EXTENSION TO PROPERTY @ 17 MUIR PLACE FORFAR
FOR STEWART HAY
REFERENCE 24/00010/FULL

We refer to our planning application for the above site
Further to receipt of your comments respond as follows.

EXIST SOUTH ELEV @ 1:200 @ A3

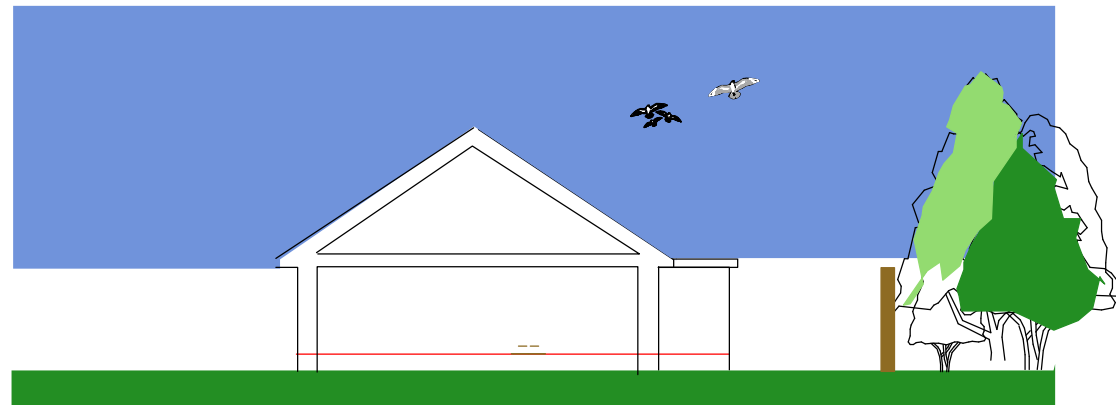
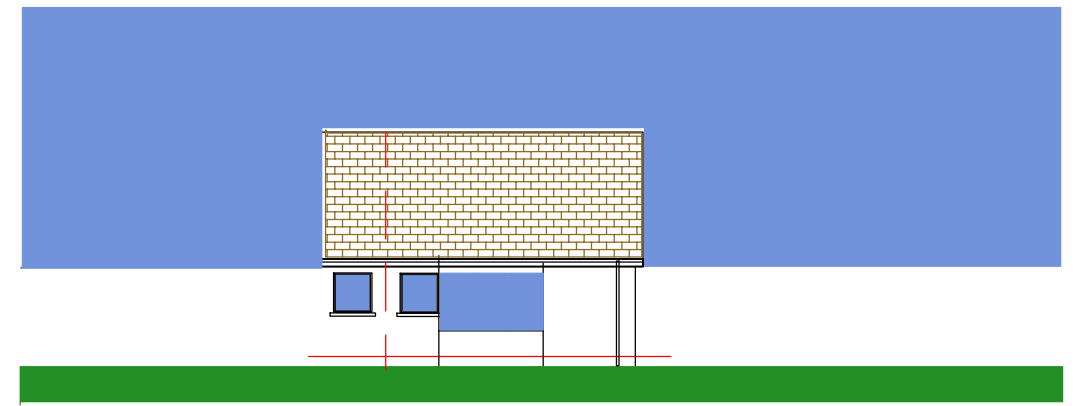
Proposed / existing elevations

1. fair point the line thickness was 0.5 and now corrected to 0mm...

PROP WEST ELEV @ 1:200 @ A3

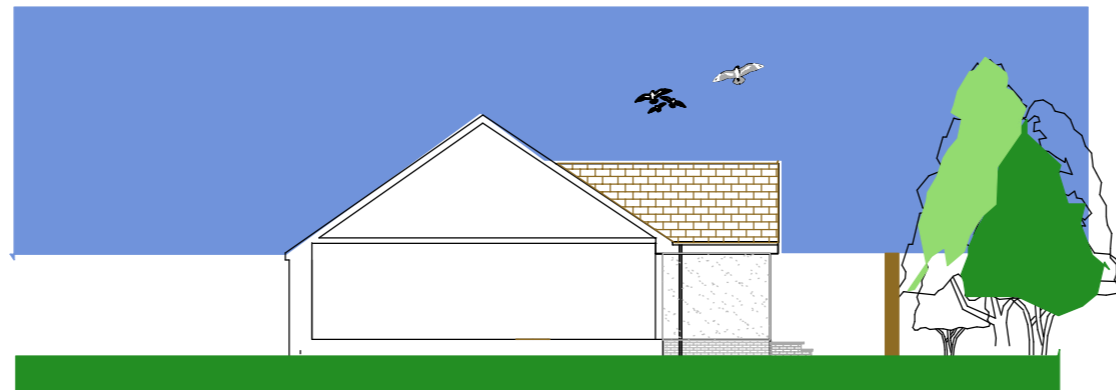
Proposed west elevation

1. neighboring window added to the elevation's (not requested previously)
2. 45 degree downward angle included .. (not requested previously)
3. 45 degree angle from the boundary as 2m as requested . (not requested previously)

PROPOSED PLAN @ 1:200 @ A3

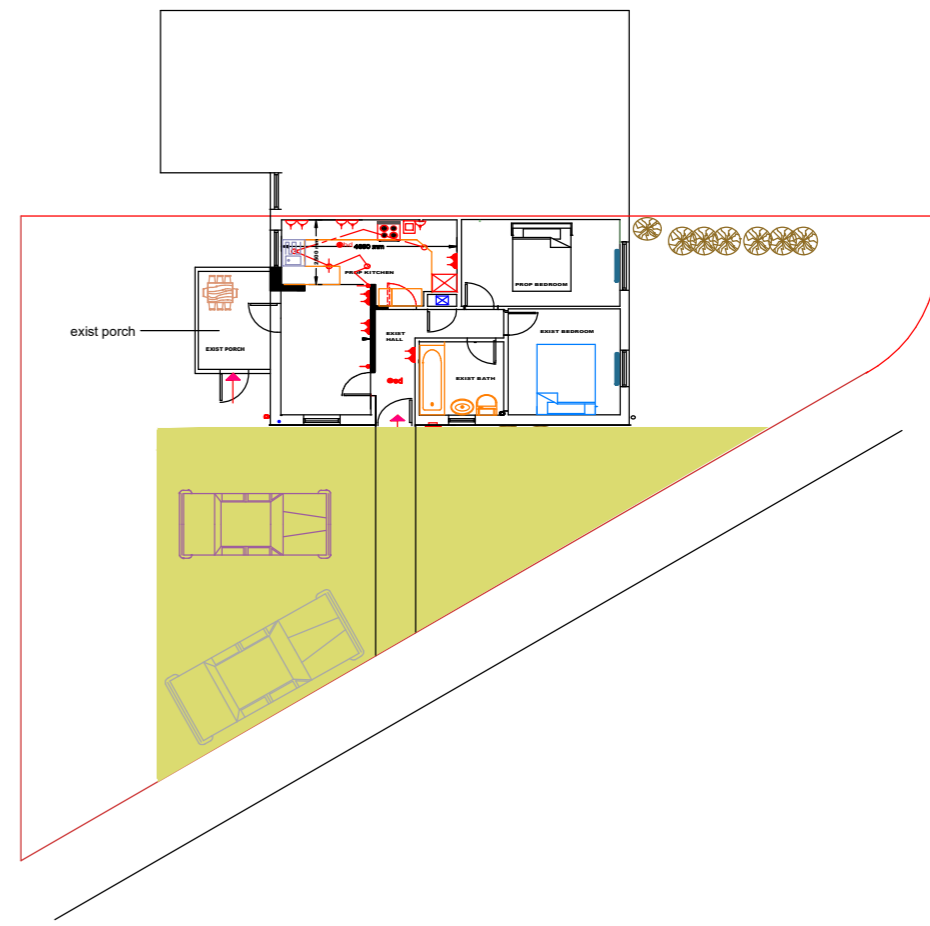
Proposed floor plan

- 1 The property does not fit the paper space hence why included it on the site plan however have shown some context of the nearest portion on the floor plan .(not requested previously)
